Our Ref: FP/205/18/HH

**Town & Country Planning Act 1990 (as amended)
Town & country Planning (Development Management Procedure) (England) Order 2015
Application for Planning Permission for Works or Extension to a Dwelling**

Development New entrance & double height hallway to front elevation, first floor extension over existing single storey side extension, single storey rear extension with glazed doors to balcony, creation of first floor balcony, single storey rear extension & cladding to entire dwelling.

Location 28 Sea Drive Felpham

BLOCK PLAN 1:500

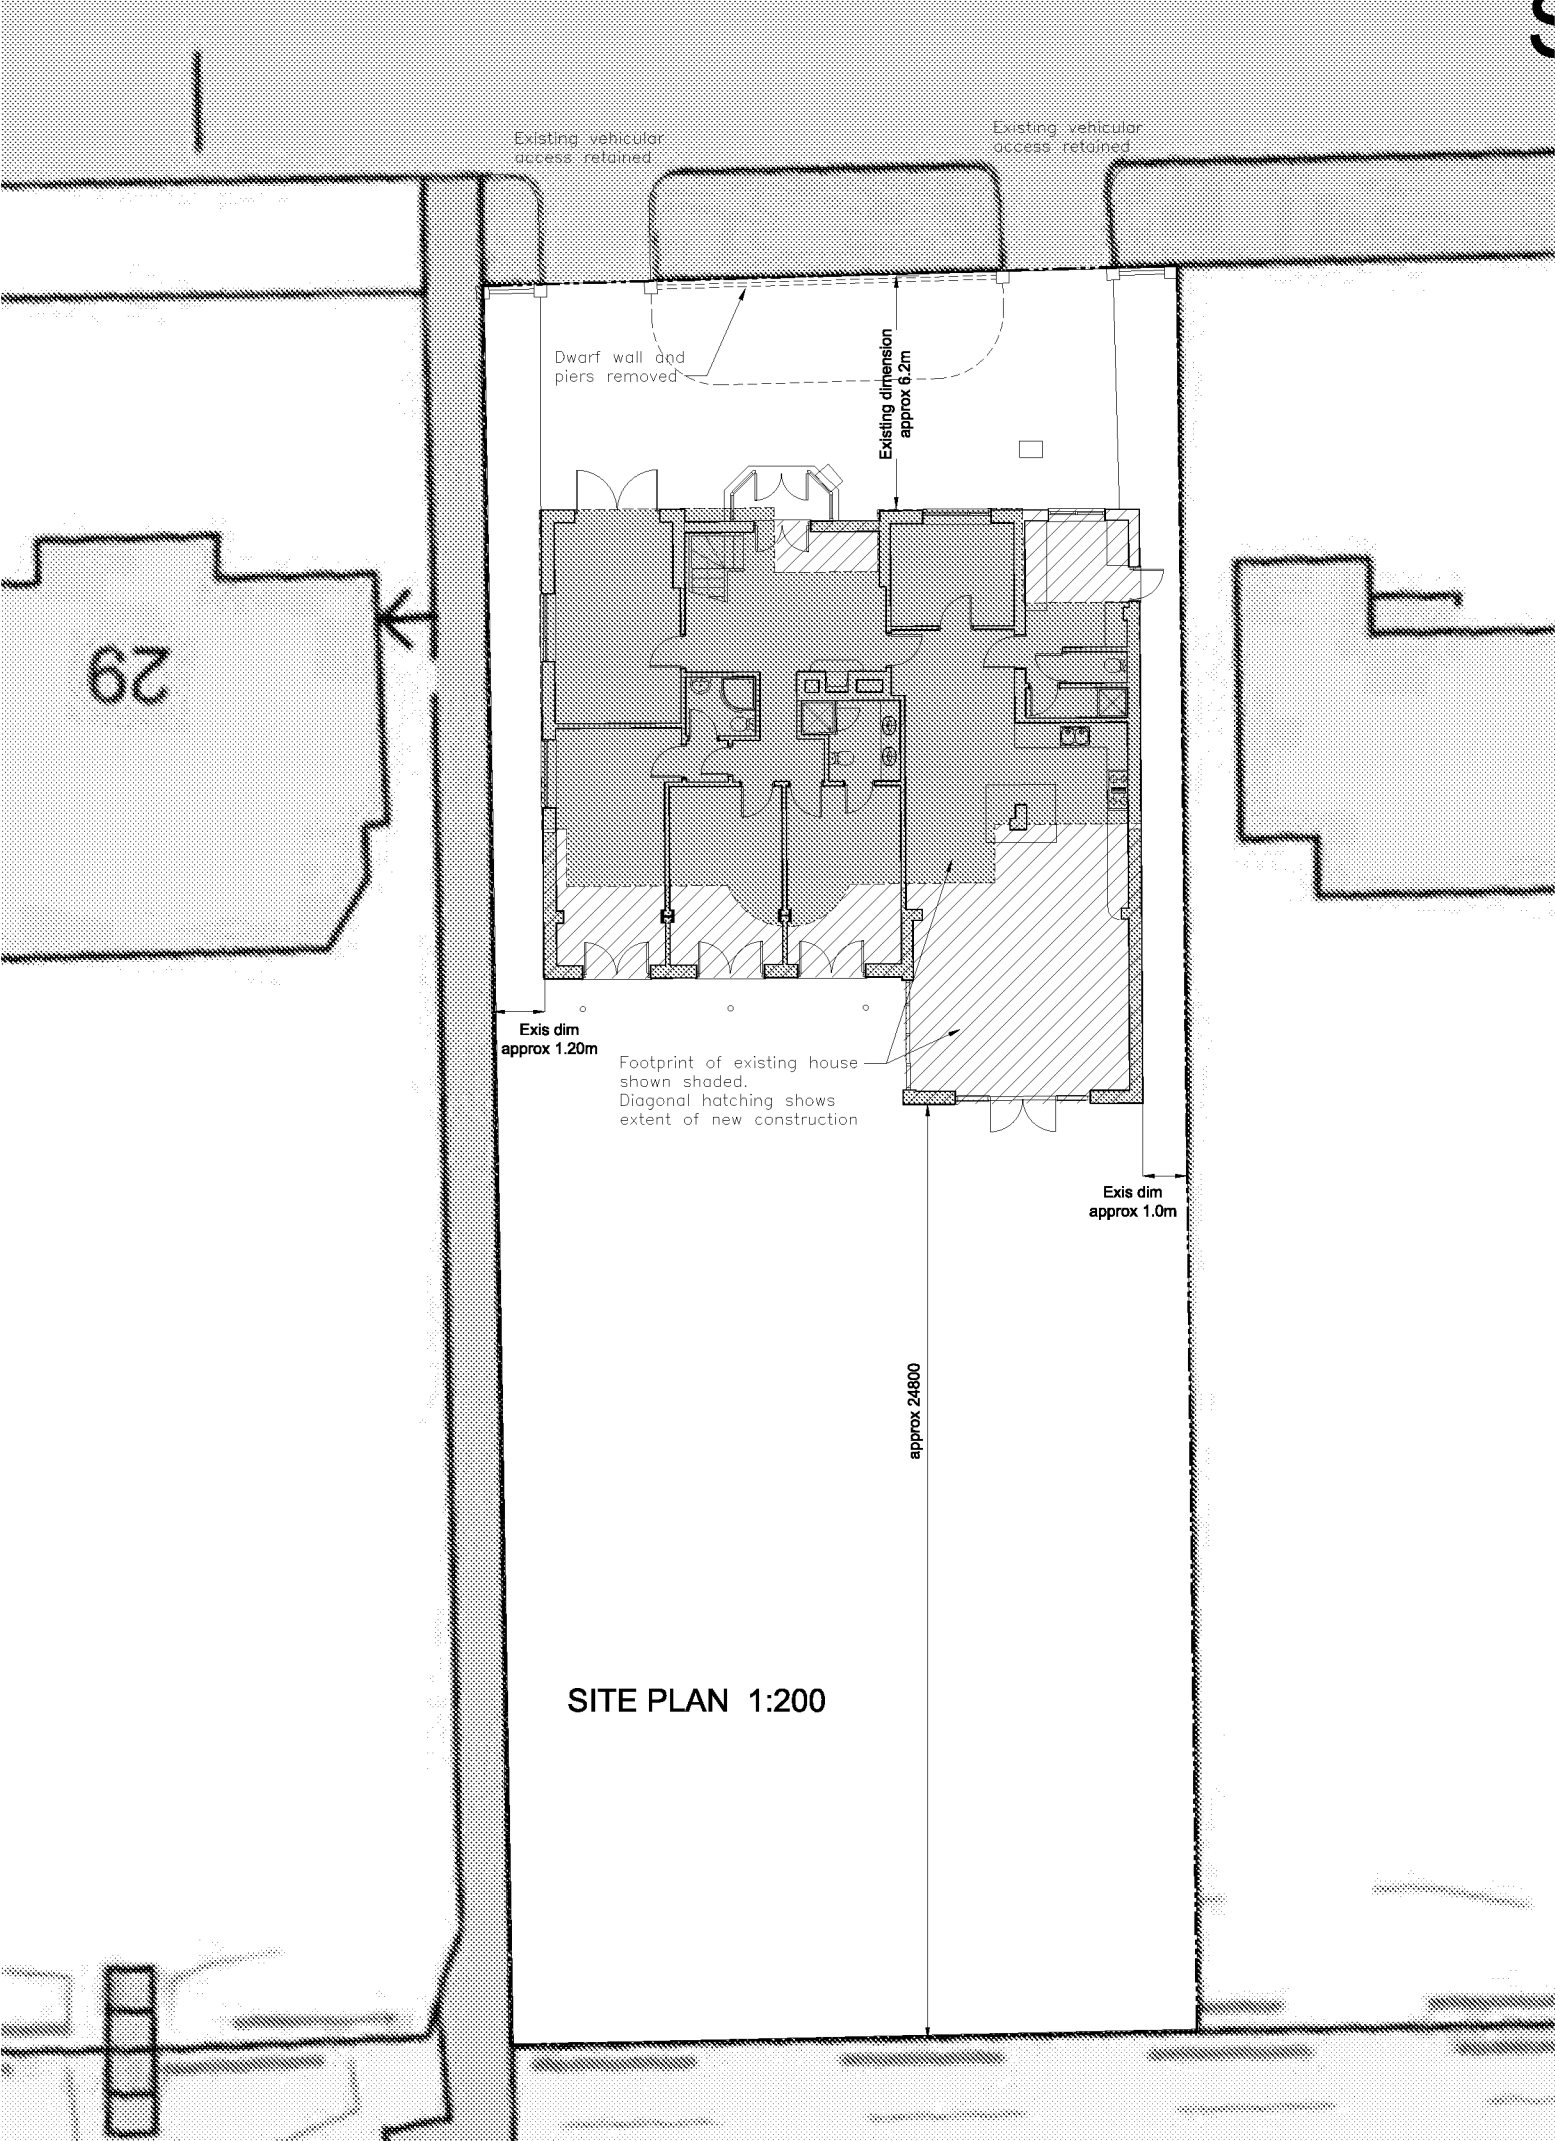
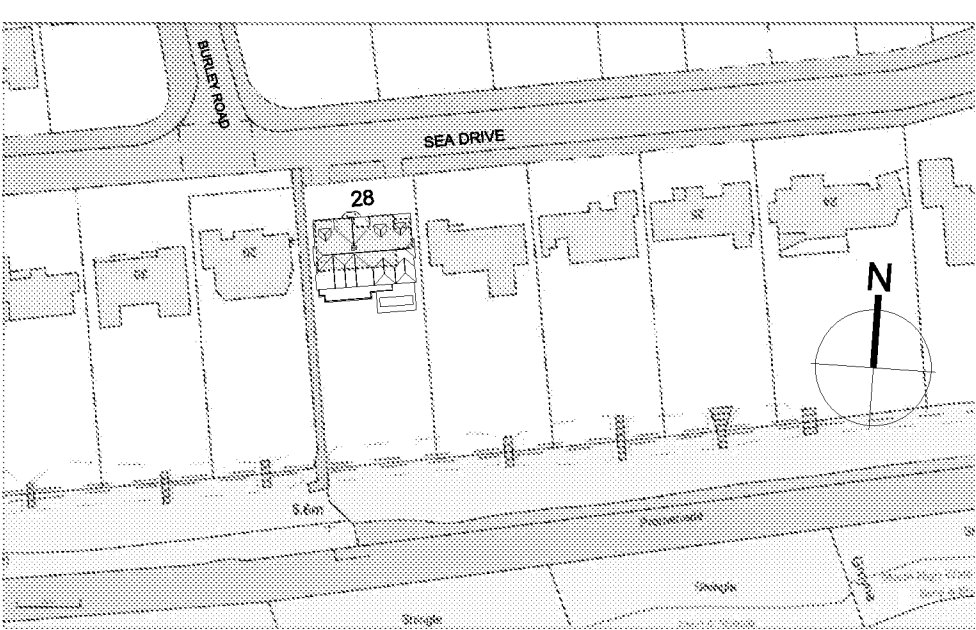
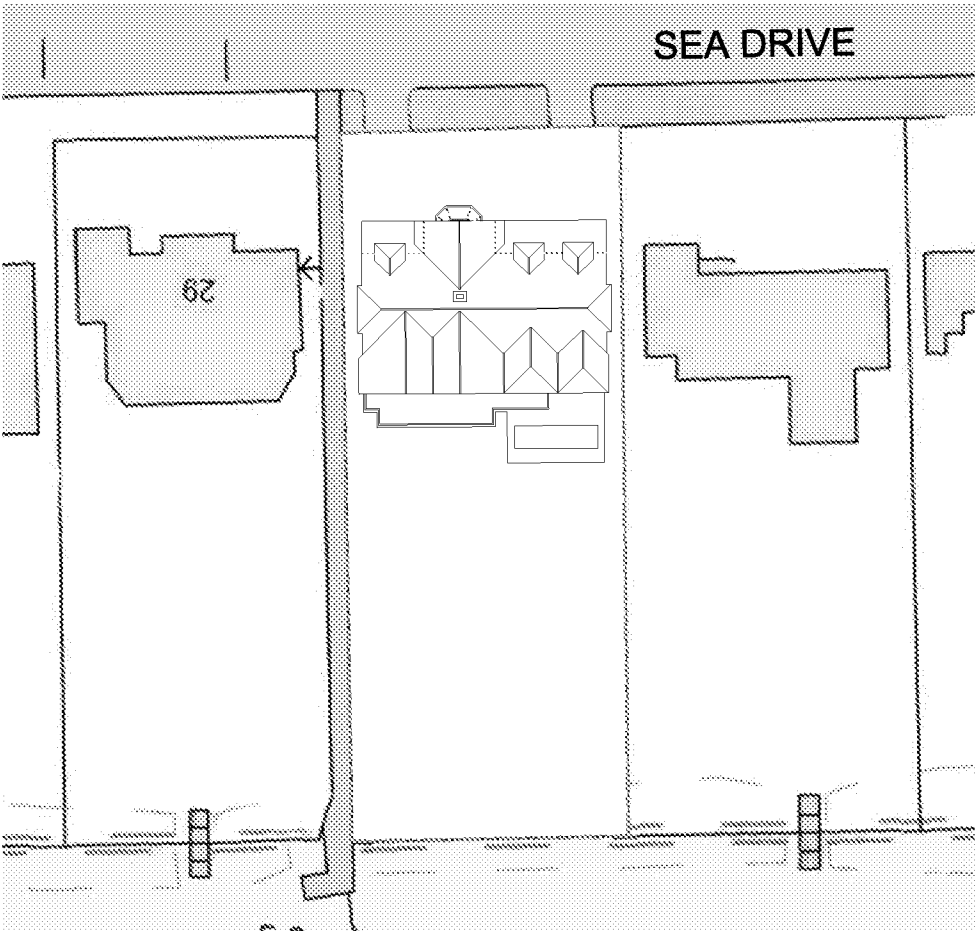
Block Plan Amend

Please clearly highlight the proposed extensions and provide measurements from the proposed extensions to the site boundaries.
